Your ref 3/2011/0865
Our ref PG/EVP/ER/3/35/8356/LK
Date 12 January 2012

APPLICATION NUMBER 3/2011/0865
SQUIRE HOUSE, CLITHEROE ROAD, KNOWLE GREEN, LANCASHIRE,
PR3 2YS
GRID REFERENCE 364846 438410

I refer to your consultation letter concerning the above application and have the following comments to make.

Revisions
Not to be scaled
© Harrison & Pitt Architects Ltd
Project
Proposed Agricultural Barn
Squire House
Knowle Green, Ribchester.
for Mr & Mrs D. Robinson
Title
PROPOSED PLANS, ELEVATIONS
AND SECTION
Drawing number
1633-011 1:100 @ A1 10/11

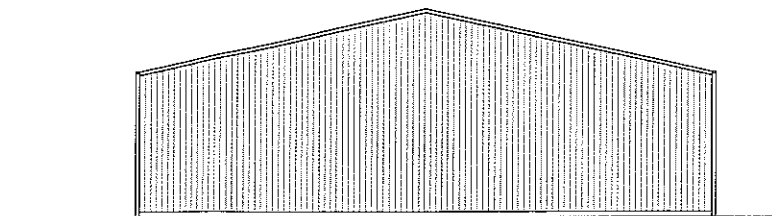
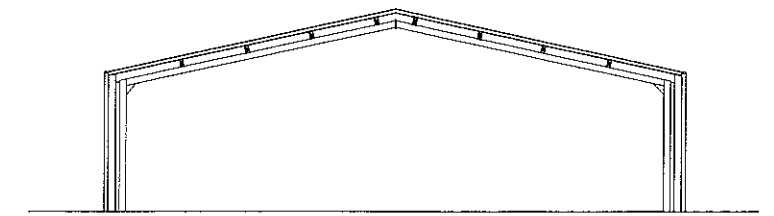
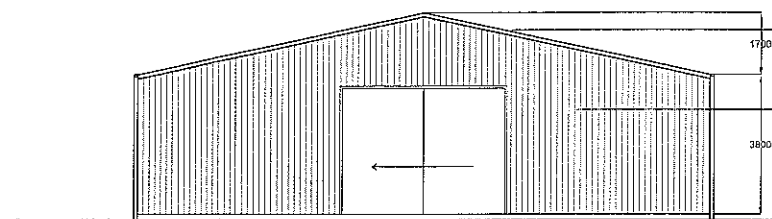
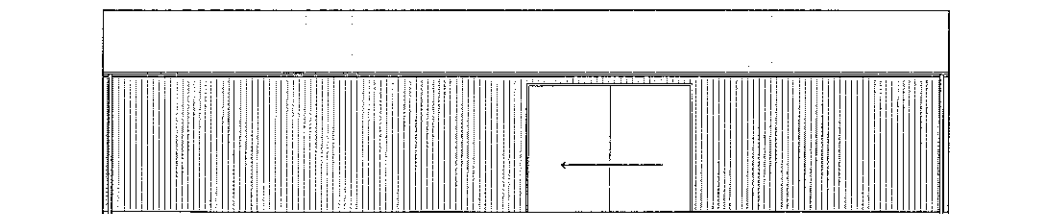
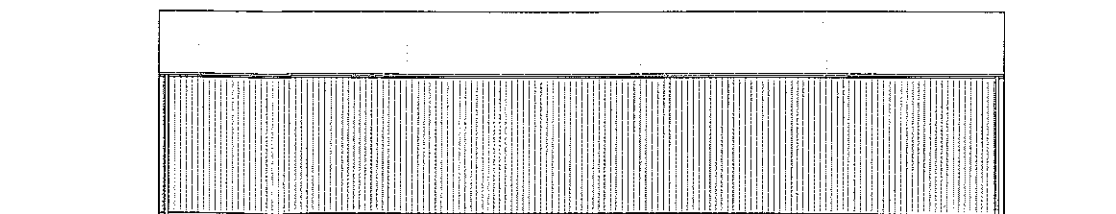
Please note that half height internal concrete panelled wall and a ventilated ridge will be incorporated within the design but are not shown on the plans submitted.

The materials proposed to be used for the building are suitable for the intended use and would allow for good ventilation through the building. However, in terms of the building's design, given that the building will have multiple uses, with one of the principle uses being for the storage of hay, it is my opinion that access is limited and a part open fronted building would be more suitable for the intended use, allowing for easy access to and from the building.

In terms of the size of the proposed development, taking into consideration the current circumstance, being that the land at Squire House is occupied by a third party and only a limited amount of hay can be cropped from the applicant's ownership, the building, in my opinion, is larger than necessary. However, notwithstanding my comments above, consideration needs to be given to the fact that the existing occupants are on short term agreement, it is the applicant's intention to take the land in hand in the near future and the applicant is in the process of improving the grassland at Squire House, in order to produce a greater amount of hay.
